Our ref: DOC22/105779  
Senders ref: SSD 11429726

**Subject: Response to Submissions - Eden Street, Arncliffe Mixed Used Redevelopment**

Figure 1: Root investigation near Tree 109 and two exposed roots. All levels located between the exploratory trench and site boundary to be retained and protected (green hatch).

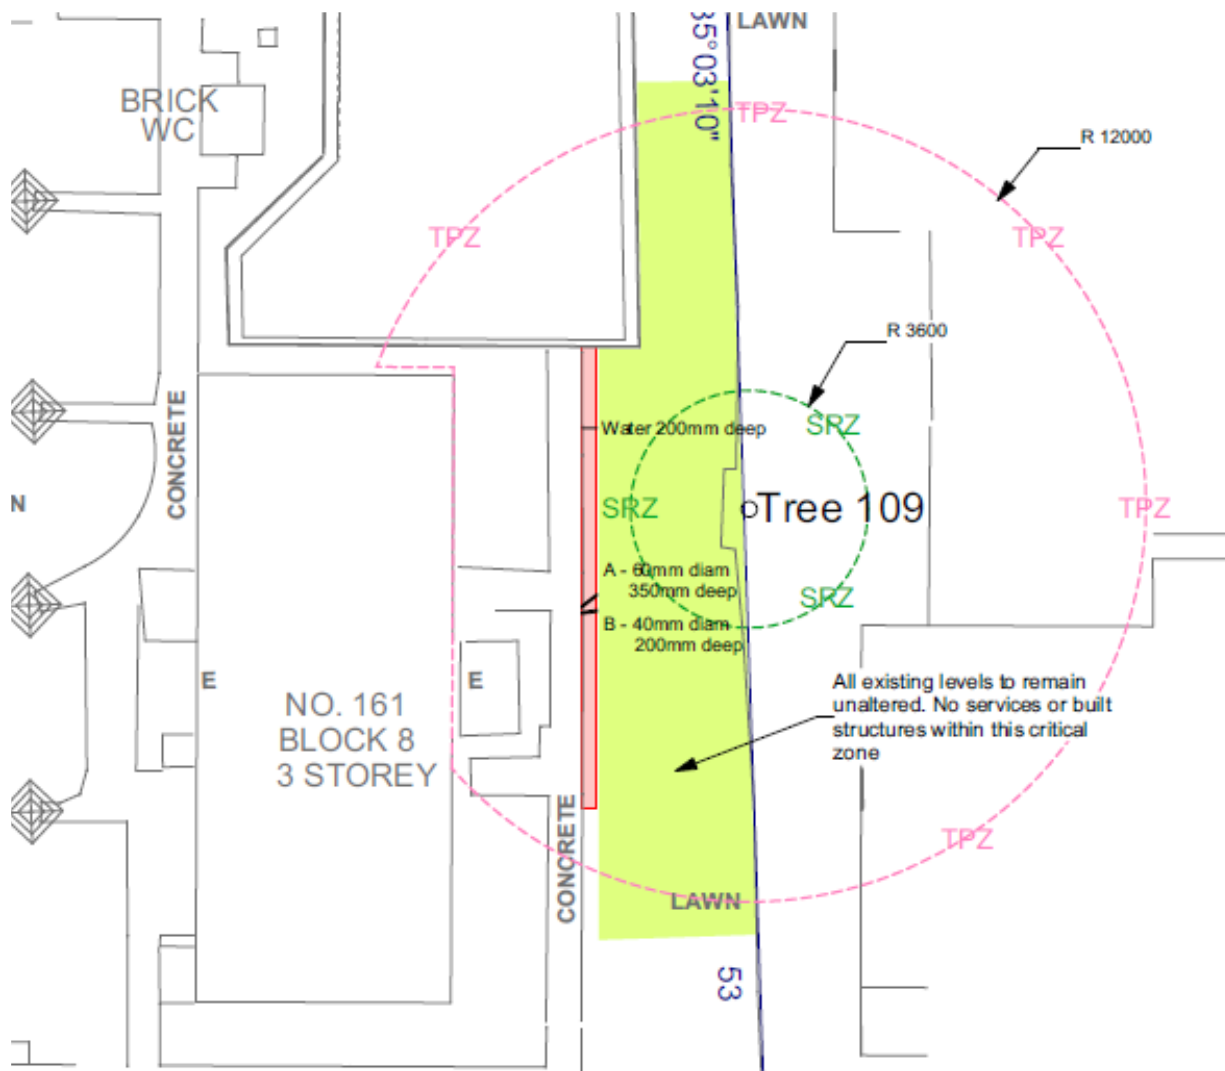
In relation to tree 109, the new AIA notes that proposed impacts are sustainable provided there is no excavation within the tree protection zone (TPZ) and that existing structures such as paths, are replaced within the existing footprints. This recommendation is not consistent with amended landscape and architectural plans which show proposed level changes and the installation of new structures including paths, a ramp, boundary walls and raised planters within the TPZ of the tree.

EES notes that the previous AIA prepared by Naturally Trees made similar recommendations for the retention and protection of tree 109. In particular, the report recommended that existing levels between the tree and the exploratory trench (as detailed in the report), must remain unaltered and that there is to be no services or built structures placed within this critical zone. This recommendation was informed by a root mapping exercise.

EES supports the recommendations of both reports in relation to tree 109 and reiterates EES's previous comments that the proposal, particularly the landscape design within the TPZ of tree 109, be amended to reflect the recommendations of the AIA.
